Our Ref: DOC19/979687

**RE: Notice of Exhibition – Royal Hall of Industries, 1 Driver Avenue, Moore Park (SSD 9726)**

I refer to your email dated 8 November 2019 inviting comments from Heritage, Department of Premier and Cabinet (Heritage DPC) and advice on recommended conditions for the above mentioned State Significant Development application for the Royal Hall of Industries (RHI) at 1 Driver Avenue, Moore Park.

1 RH1 NORTH ELEVATION CONCEPT  
1 : 200

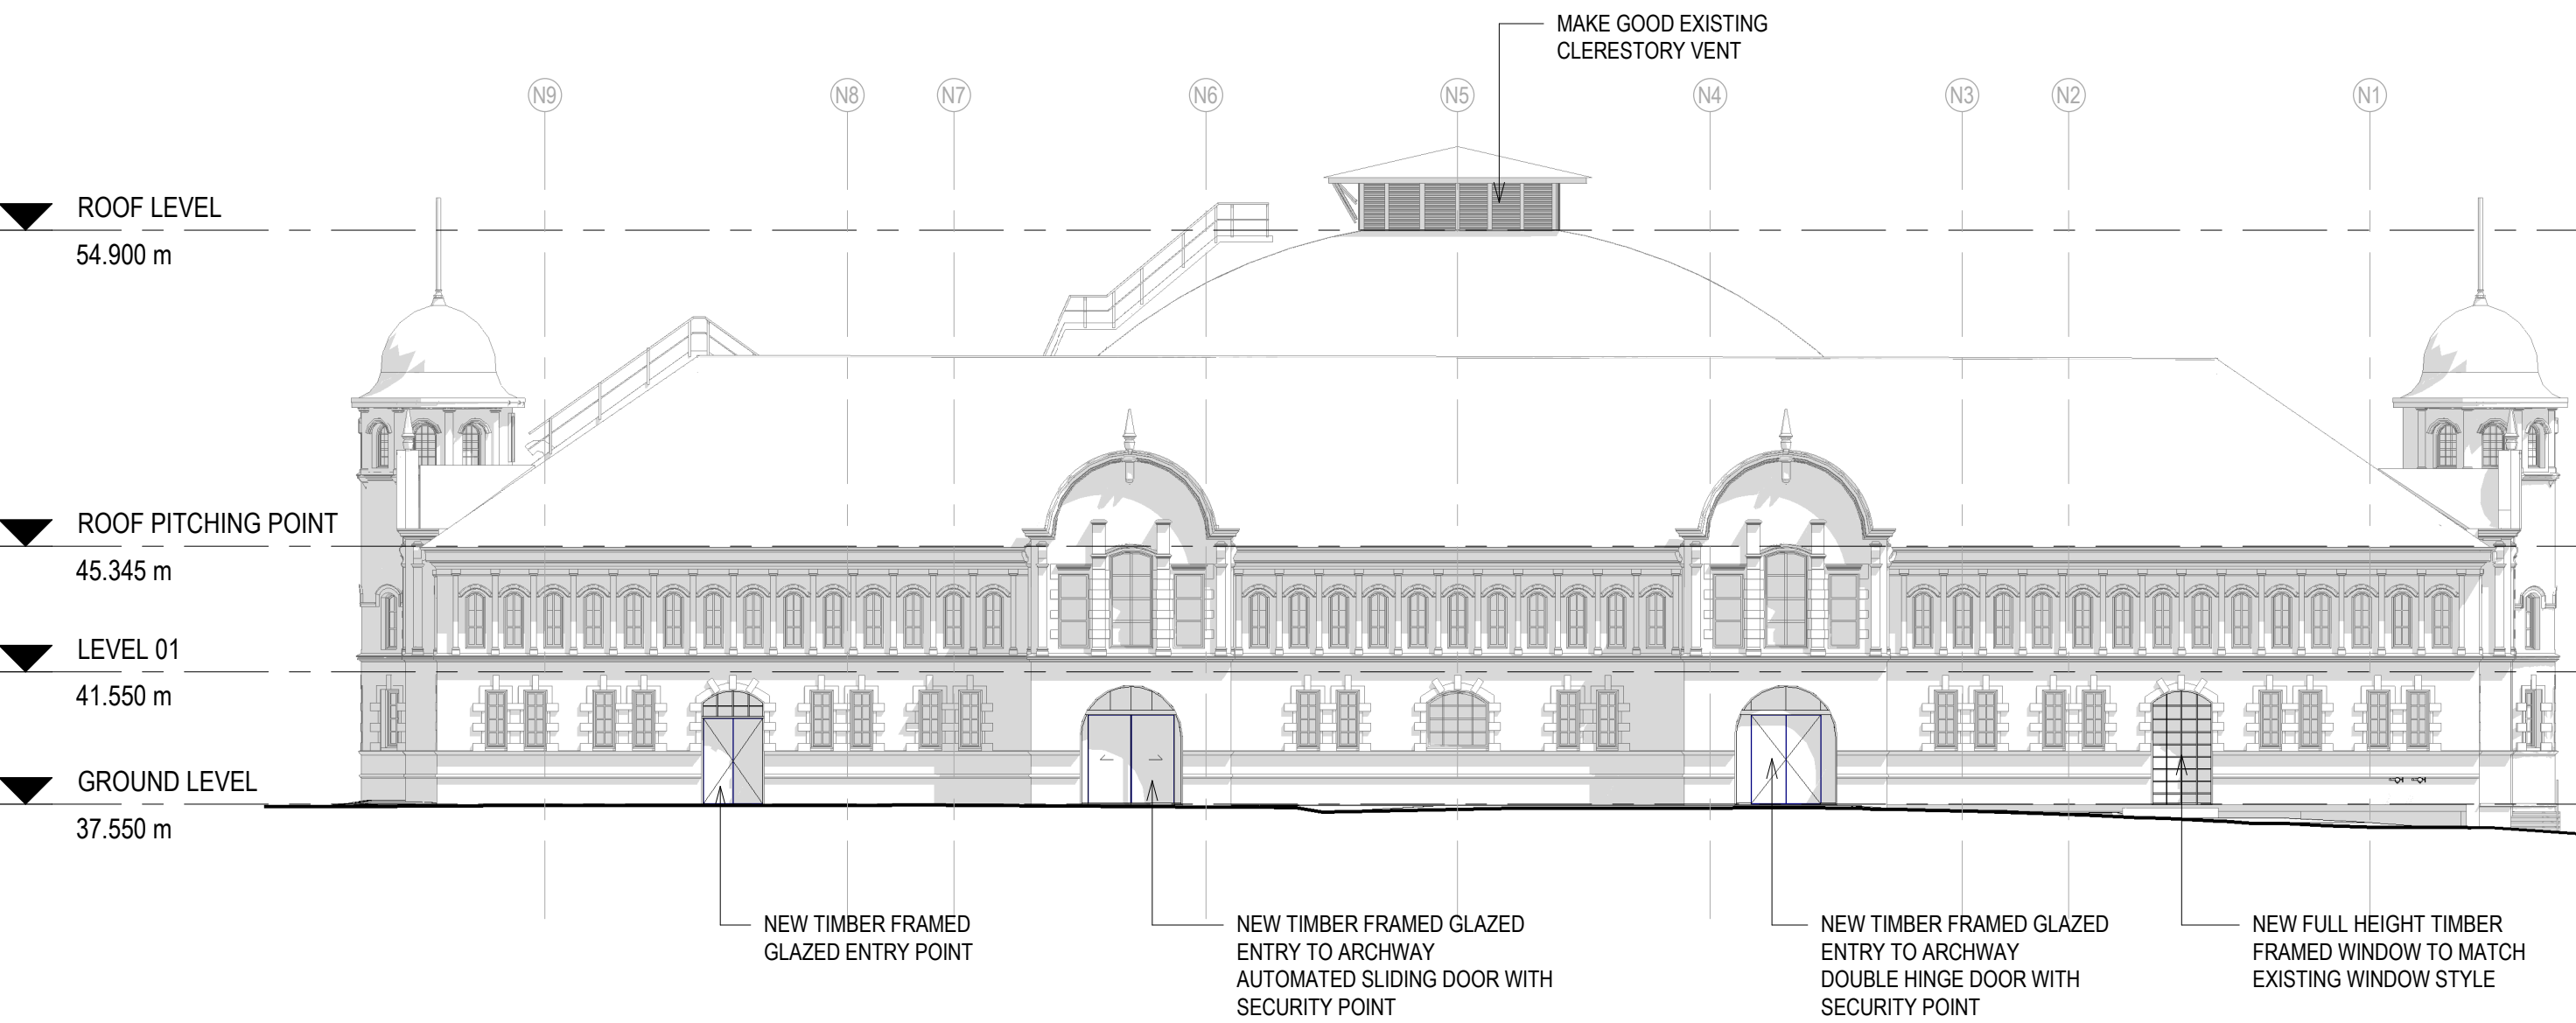
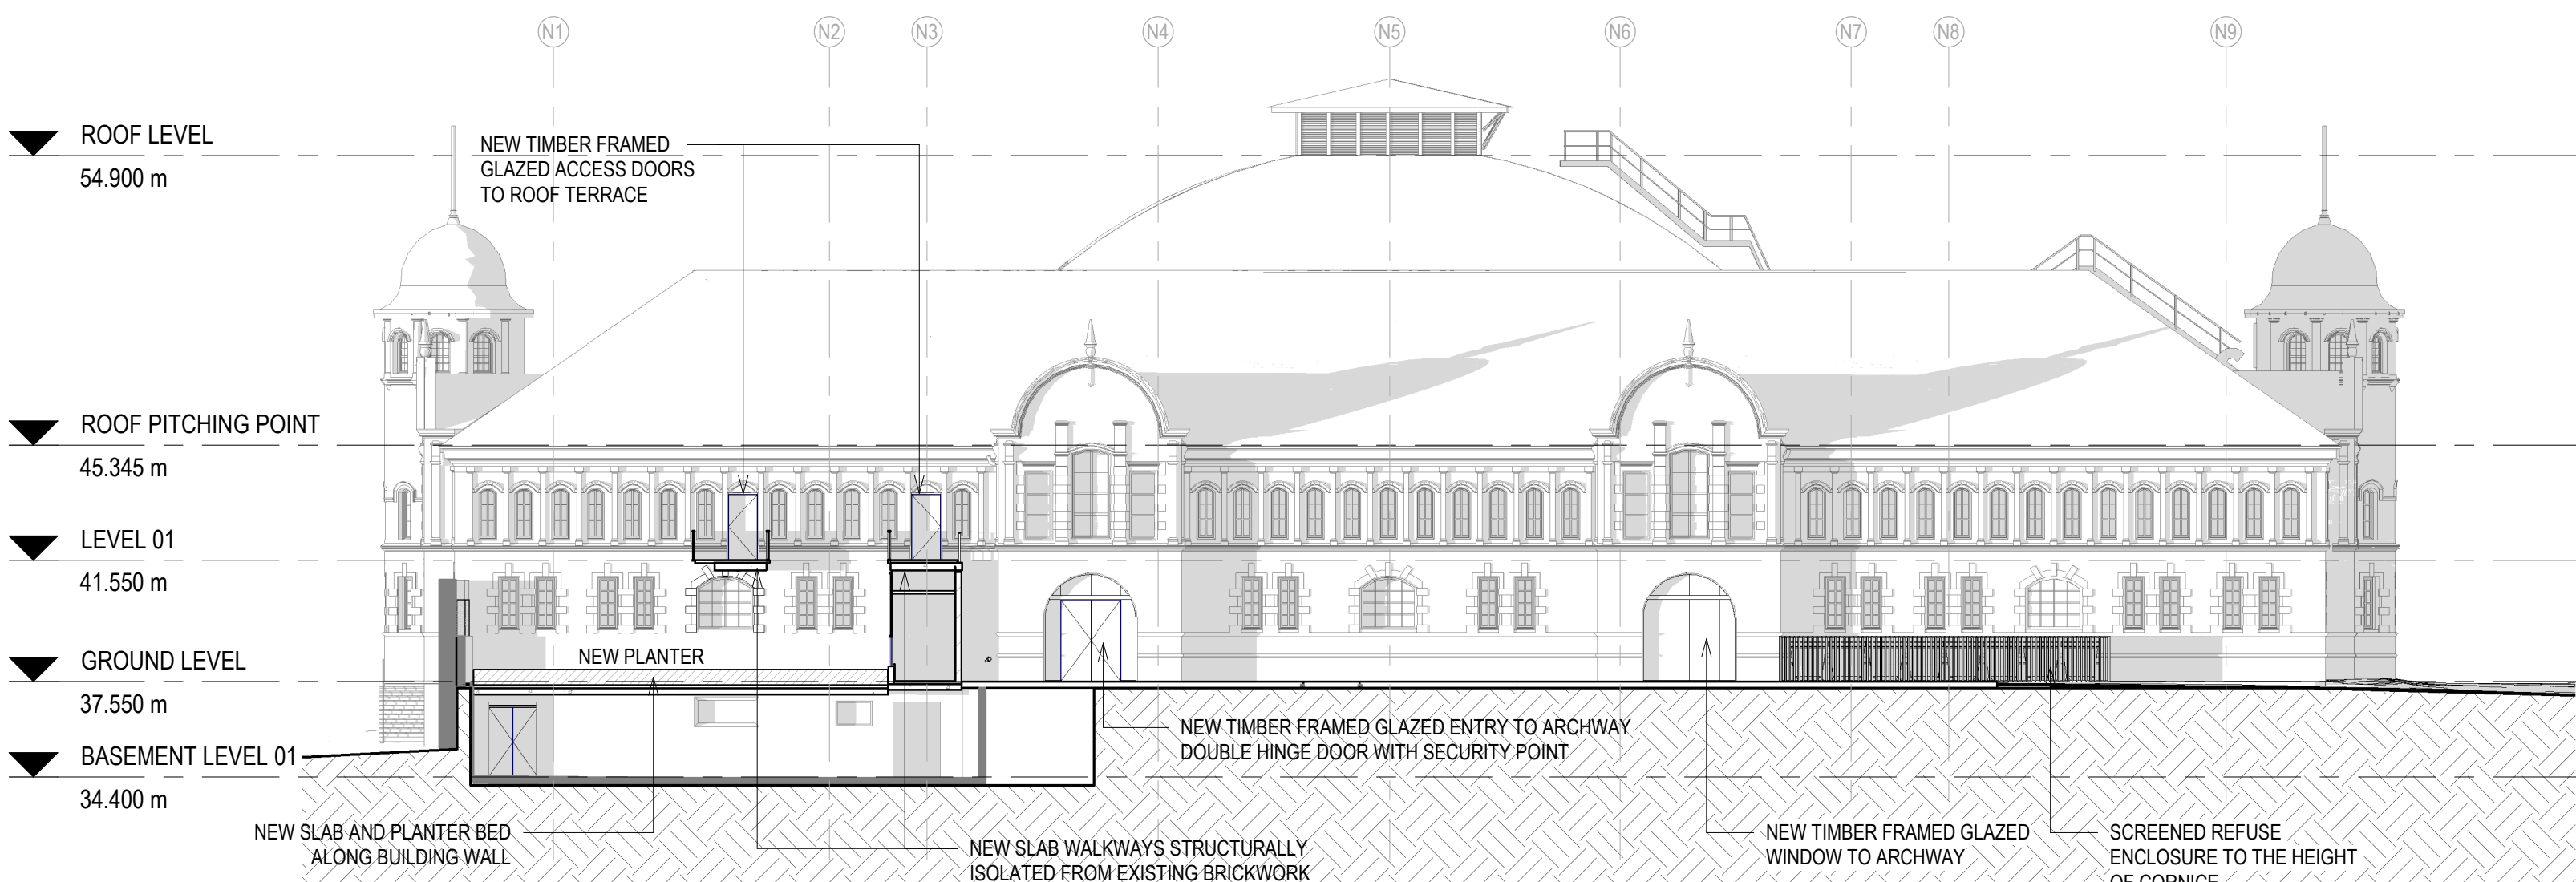
- The proposal involves creating new openings to the north and south facades of the building. Any proposed works to the exterior facades should be guided by Policy 3.3 of the CMP which states that the existing pattern of windows and door openings be retained and conserved. Further, all original timber joinery should be salvaged and stored on site. Any opportunities to reinstate missing elements such as missing arched hoods from door and window openings should be undertaken.

- In relation to the proposed waste storage unit proposed to the south façade of the building; details of fixings should be provided prior to the issue of a construction certificate. It is understood that the location of the storage unit is in a historically back of house area and will have the least visual impact compared with other facades.

There should be no cutting or chasing into external brickwork or cement render and the installation should not adversely impact on significant fabric.
